RECOMMENDATION FOR PLANNING AND DEVELOPMENT COMMITTEE

REFUSAL

APPLICATION REF: 3/2024/1016

REGULARISATION OF WORKS INCLUDING EXTENSION TO GROUND FLOOR TO INCLUDE INTERNAL SECURE RESIDENTS CYCLE STORE WITH ROLLER SHUTTER DOOR; RE-INSTATE REAR BOUNDARY WALL TO 0.74M HIGH; ALTERATIONS TO REAR EXTERNAL STAIRCASE; UPVC WINDOWS AND DOORS TO FRONT, SIDE AND REAR; ALUMINIUM WINDOWS TO THE FRONT DORMER; SCREENING FEATURE TO THE REAR BALCONIES; GROUND FLOOR BIN STORE; CENTRAL CLADDING TO FRONT DORMER WINDOW ON THIRD FLOOR; ROOFLIGHTS; EXTERNAL LIGHTING SCHEME TO REAR AND TWO ELECTRIC CHARGING POINTS AT 1 TO 7 THE PICTURE HOUSE, GEORGE STREET, WHALLEY BB7 9TH

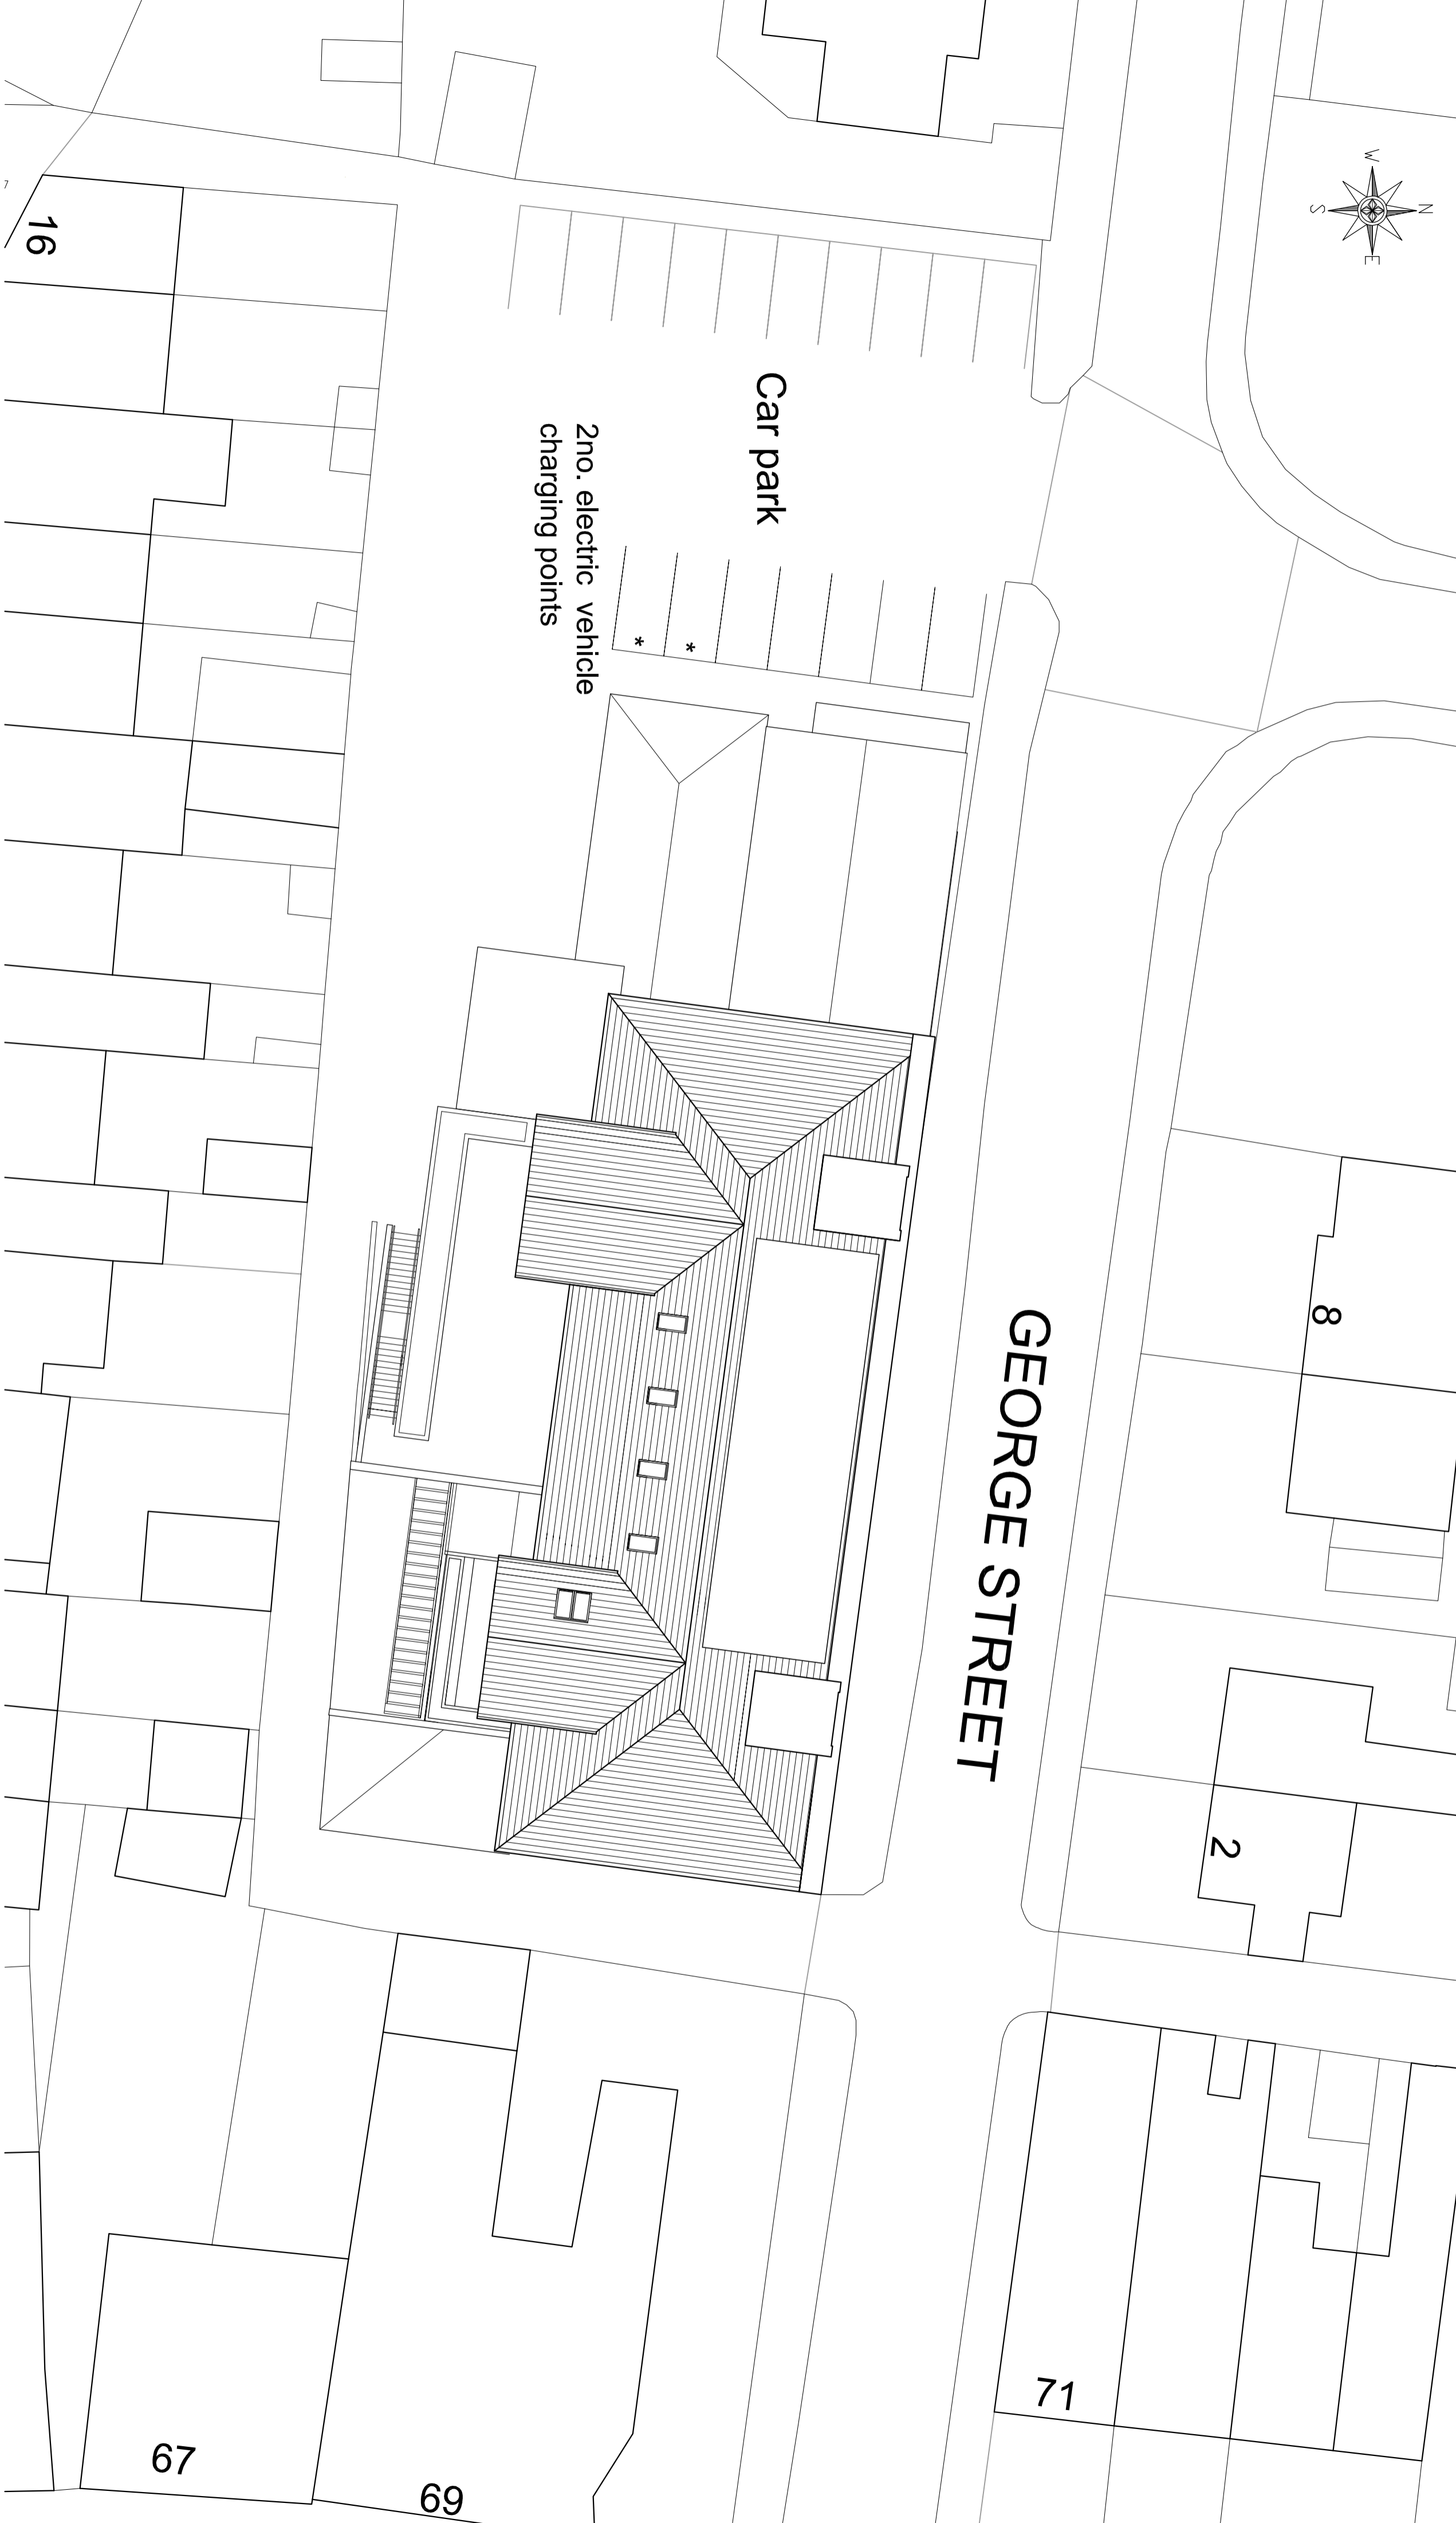
The LHA acknowledges the applicant's proposal to reduce the number of Electric Vehicle Charging Points from 7 to 2 due to power supply concerns, and the LHA does not object to this modification given the availability of public charging points nearby and the potential for residents to share the private ones. However, it remains crucial to retain the 7 off-street parking bays and ensure that the car parking plan is updated to clearly identify which bays are designated for the

residential development. This will help provide clarity and maintain the integrity of the site's parking provisions.

Drawing file: planx_downloads / 24_1016_Amended_Plans_As_Built_Side_and_Rear_Elev12mar25.pdf

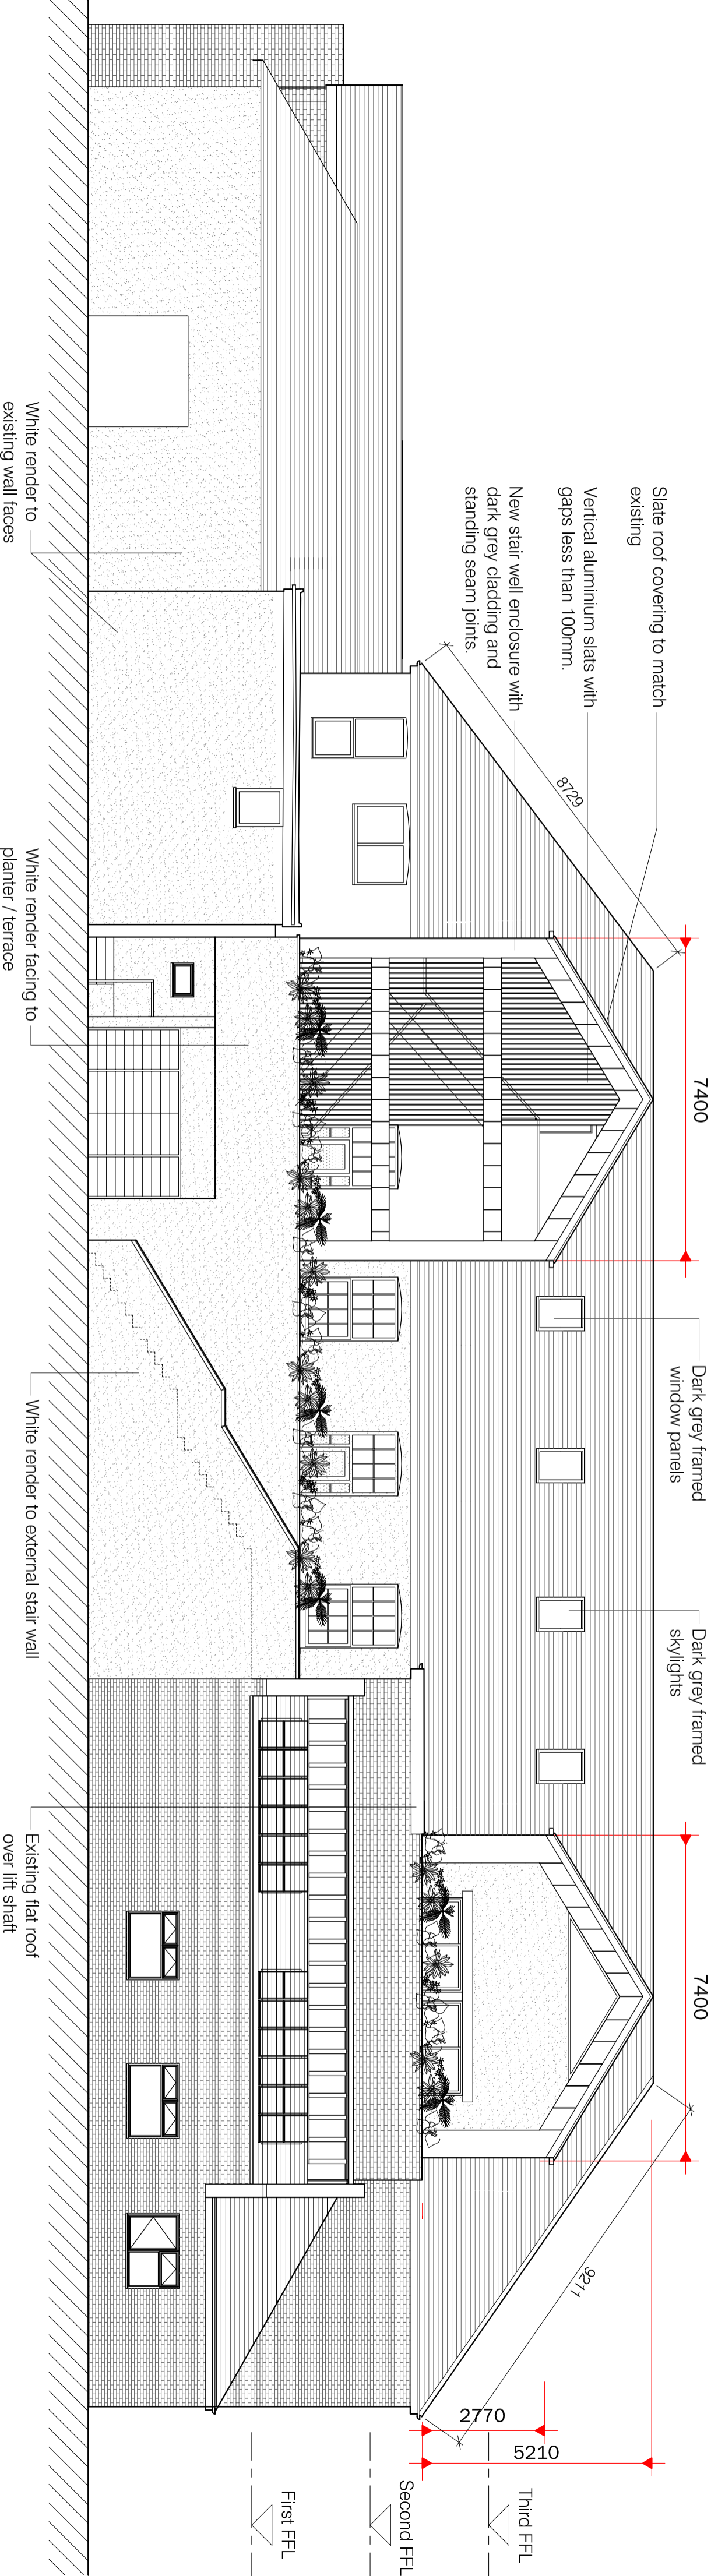
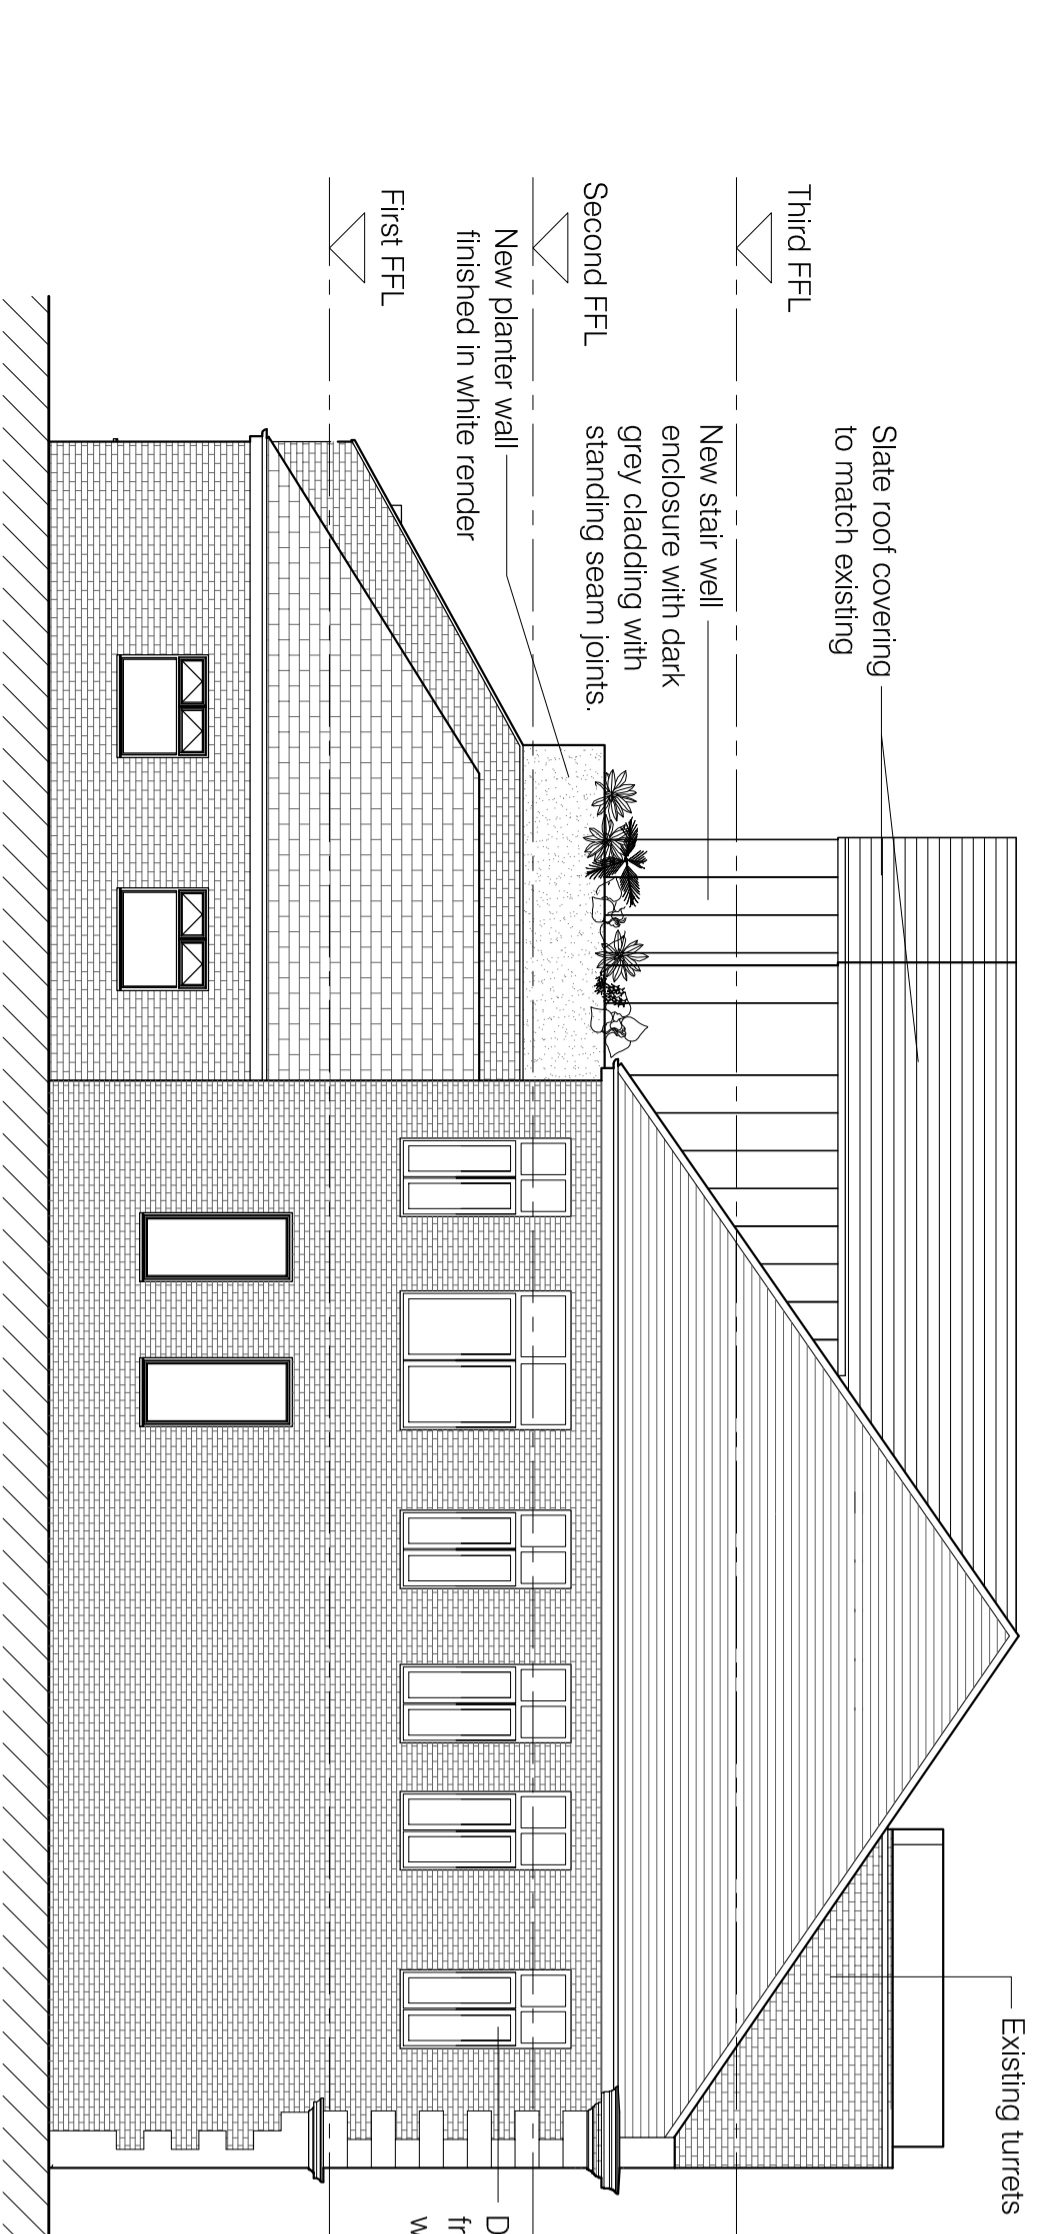
- The rear stairwell has been externally and internally finished in aluminium standing seam and not zinc (heritage material);
- The rear stairwell has lighting installed to a level which is completely unacceptable which is exacerbated by the fact it has been left open to the elements;

- The new rendered wall to the stair has an unacceptable bulk and appearance;
- UPVC windows have been installed to the entire development these are not compatible with the historic character the area and undermine the integrity of the design and character of the building. The study of the area submitted is a futile attempt to justify the installations;

- 5.2.10 With regard to the single storey extension, rear stairwell enclosure, bin store and the white render to the rear elevation, whilst stark, these do not result in an unacceptable form of development in itself when compared to the approved scheme. However, there is a lack of screening and greenery of the site and in particular softening of the large first floor terrace/balcony and its surrounding wall is considered to be required. It is proposed to introduce an artificial hedge along the perimeter wall of the first-floor terrace to help to mitigate its visual impact (as well as mitigate overlooking). However this would not be an appropriate feature in the conservation area and therefore to date no suitable mitigation has been put forward.
